About the application

Application number: 2019/90725	
What is the application for?:	Demolition of existing dwellings and erection of 9 apartments
Address of the site or building:	Land at, Busker Lane, Scissett, Huddersfield, HD8 9JU
Postcode:

User comments

Proposed Elevation 1: Front Elevation Facing Busker Lane
Scale 1:100

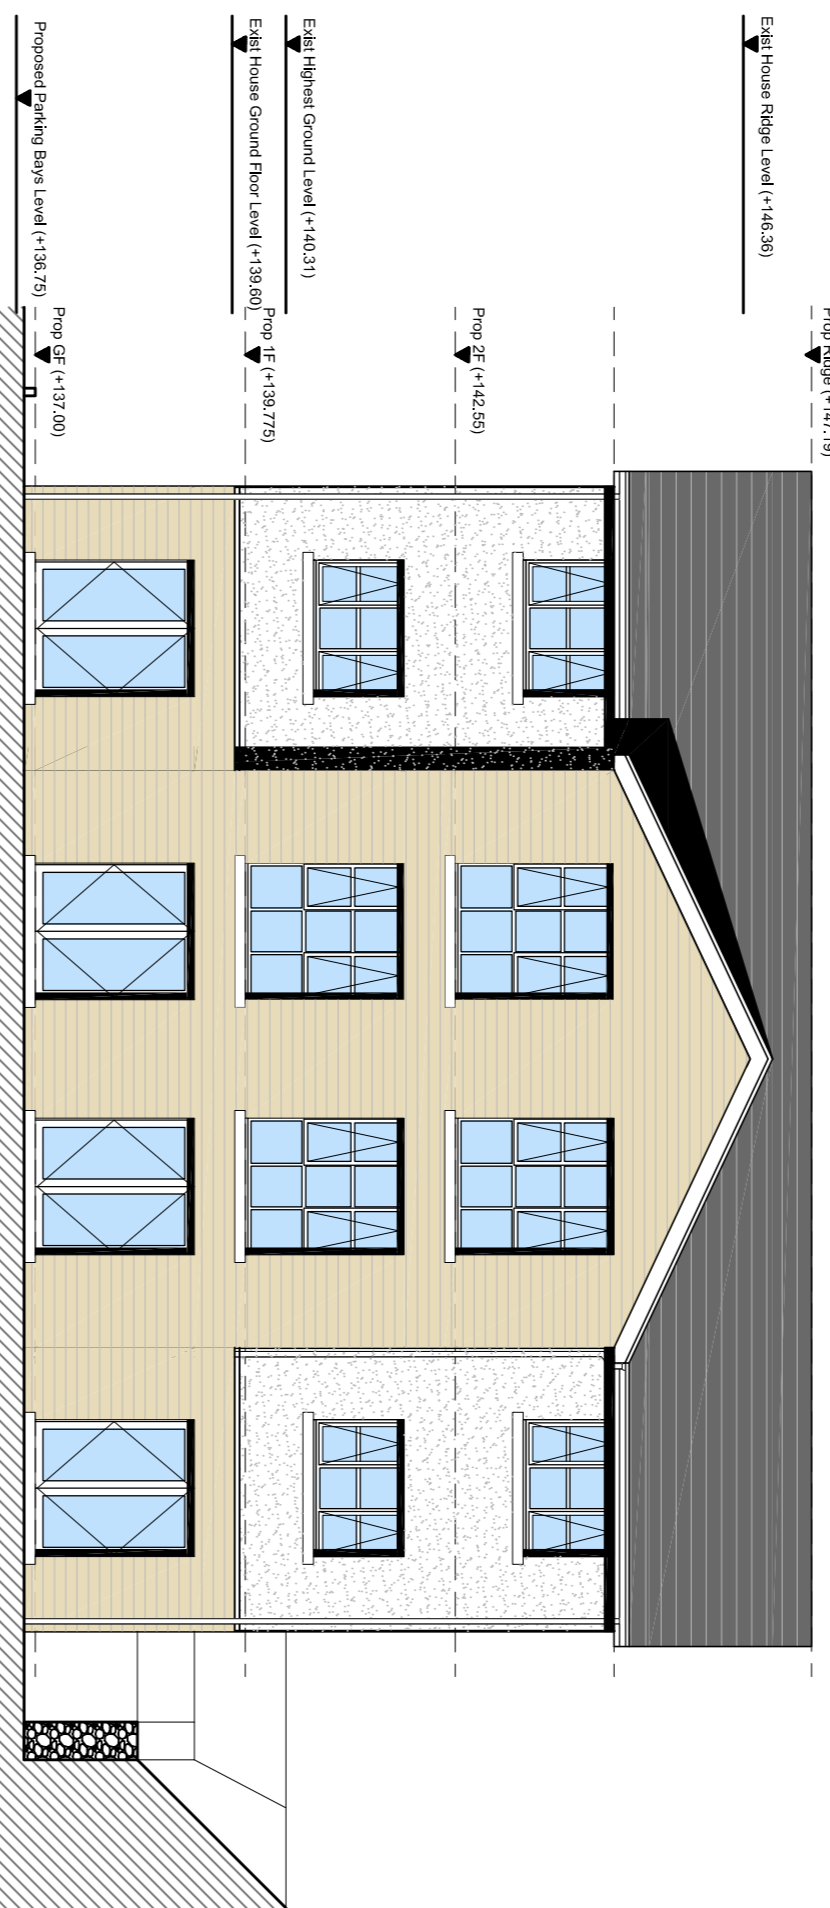
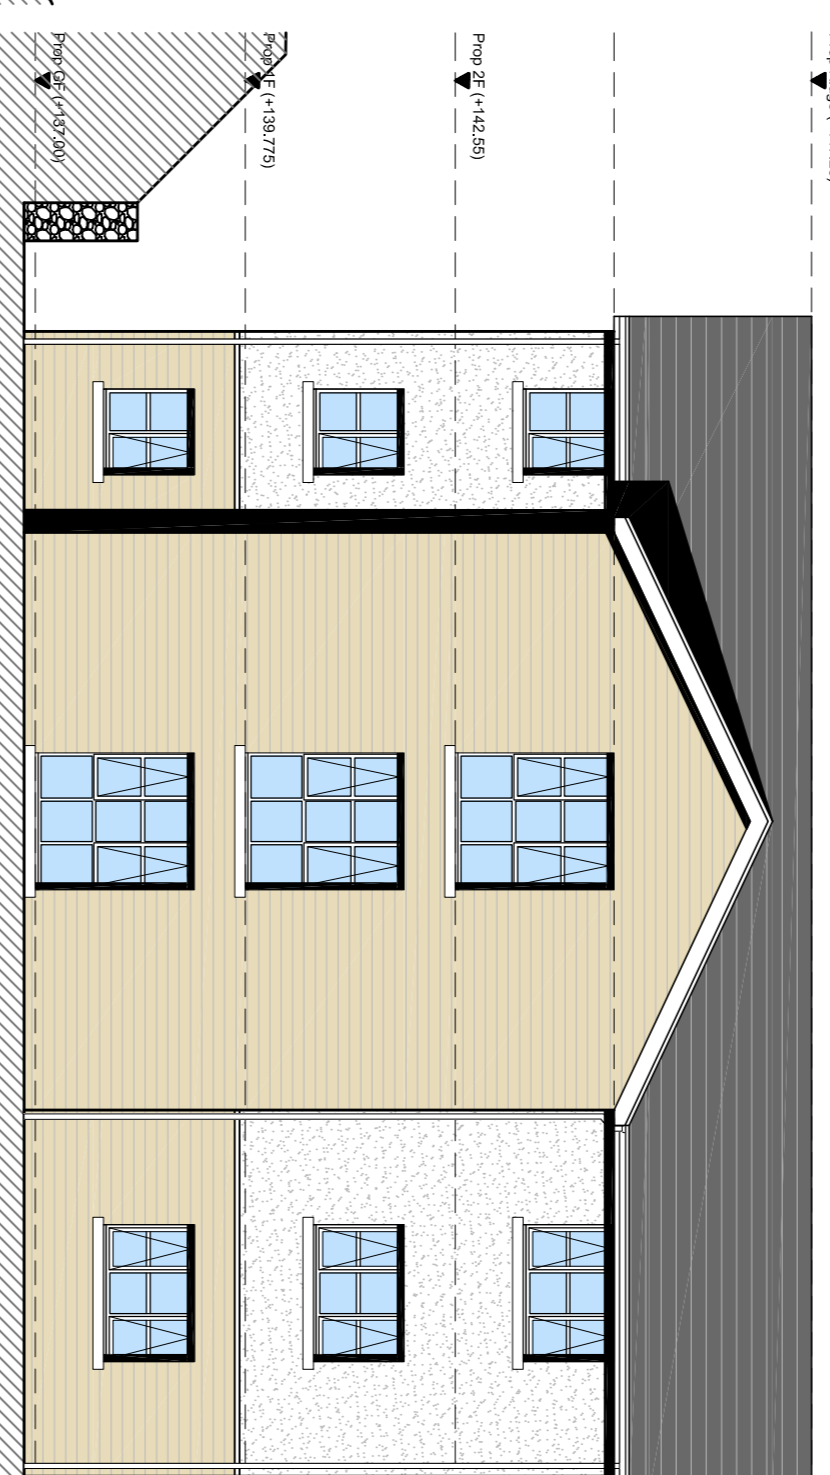
the 9 apartments which stated in para 9.16 “given the buildings set back from Busker Lane relates acceptability in scale and design “ we refer also to para 9.19 “consequently, given the location and scale of the proposed building being set back on the opposite side of Busker Lane it is not considered that the proposed development adversely affects the setting of Lower Busker Farm” which appears to have been forgotten. This further increase in development / accommodation is imposing and will be seen as a further over “massing” of the site.

Proposed Site Plan
Scale 1:200

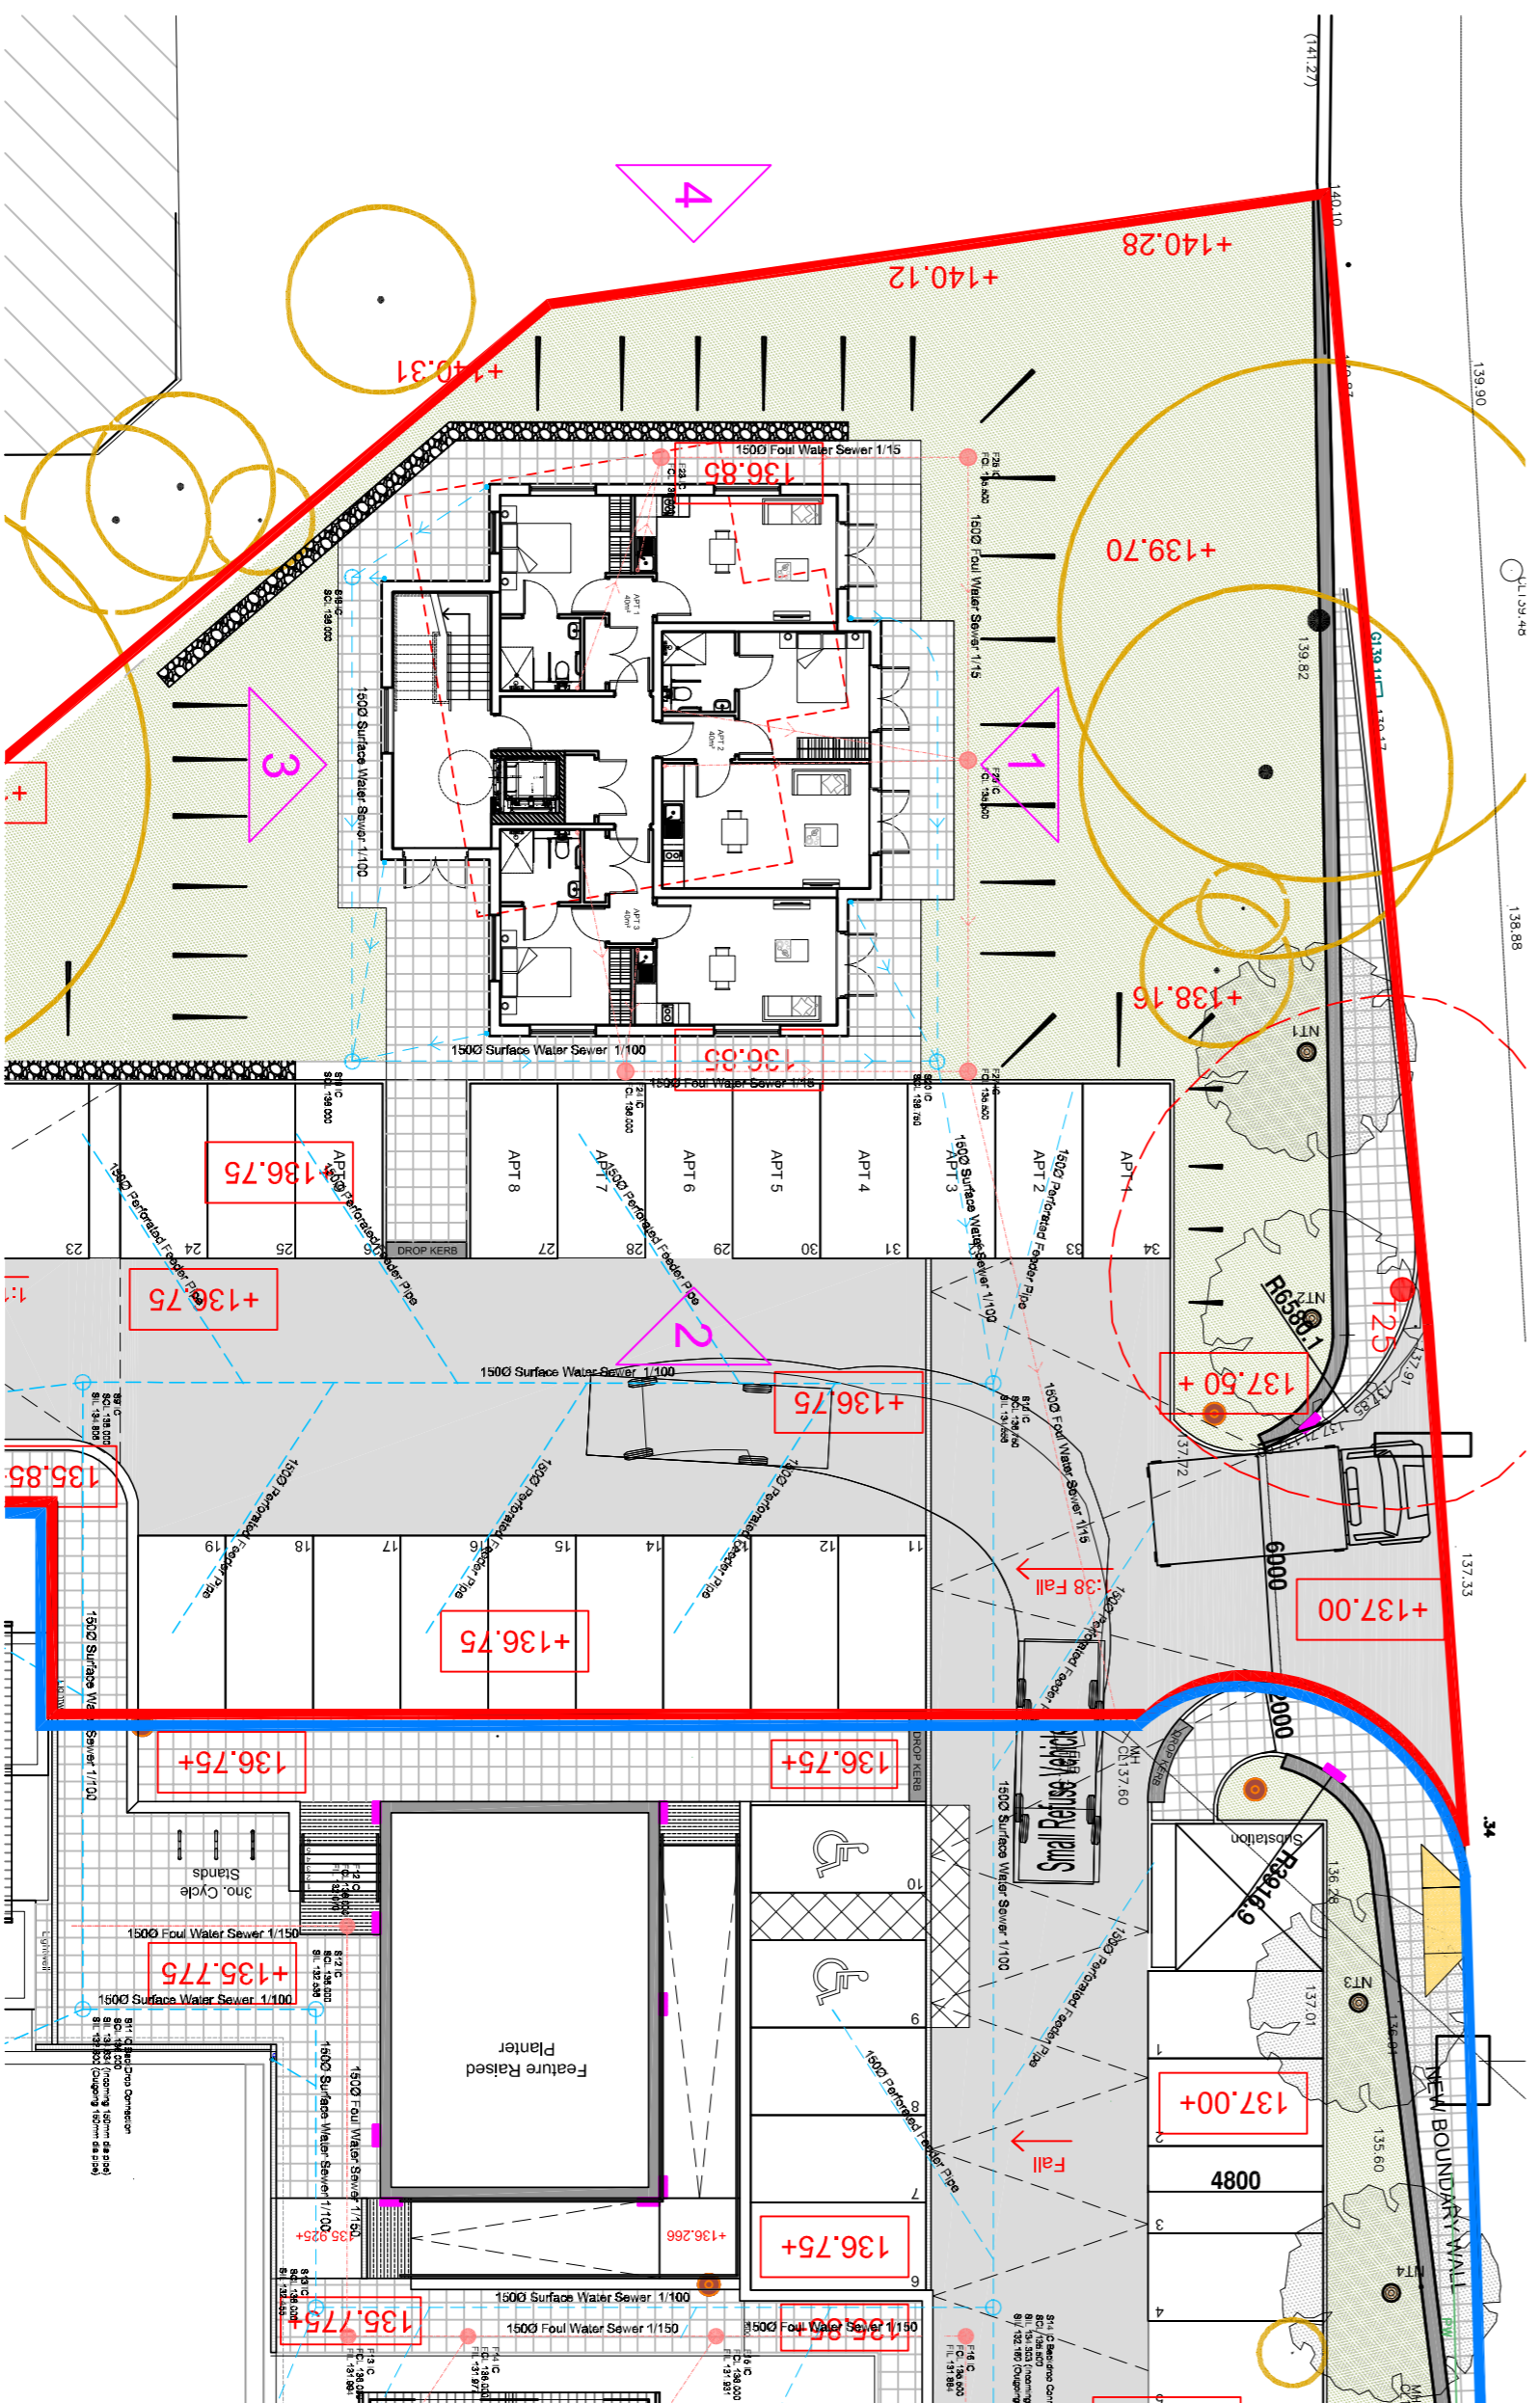
7. There is inconsistency in the submitted planning drawings in particular the Car Parking and what is currently available space wise on site. The car parking spaces do not match. As stated in item 3 above, the “proposed” application for a sub-station has reduced the numbers of car parking spaces from 27 spaces for the Care home (+3 for the existing semi-detached house) on the original application in 2017. To 23 spaces for the Care home (+ 9 for 9 new proposed apartments). Is this going to be allowed?

8. There appears to be no charging points for vehicles currently or a bike store – does this mean more disruptive construction works on site?

9. Given the ongoing changes to the site layout in particular the Car Park there is now a greater amount of light pollution from the Car Park area which washes across the road to Lower Busker Farm and is no longer screened by landscaping due to insufficient and inadequate space left for suitable planting. The planting shown on the recent submission is inaccurate, as there is no space to put in trees or screening due to mass concrete fill! Therefore, our view is now a car park and substation, something not considered in the Report mentioned in item 6 above.
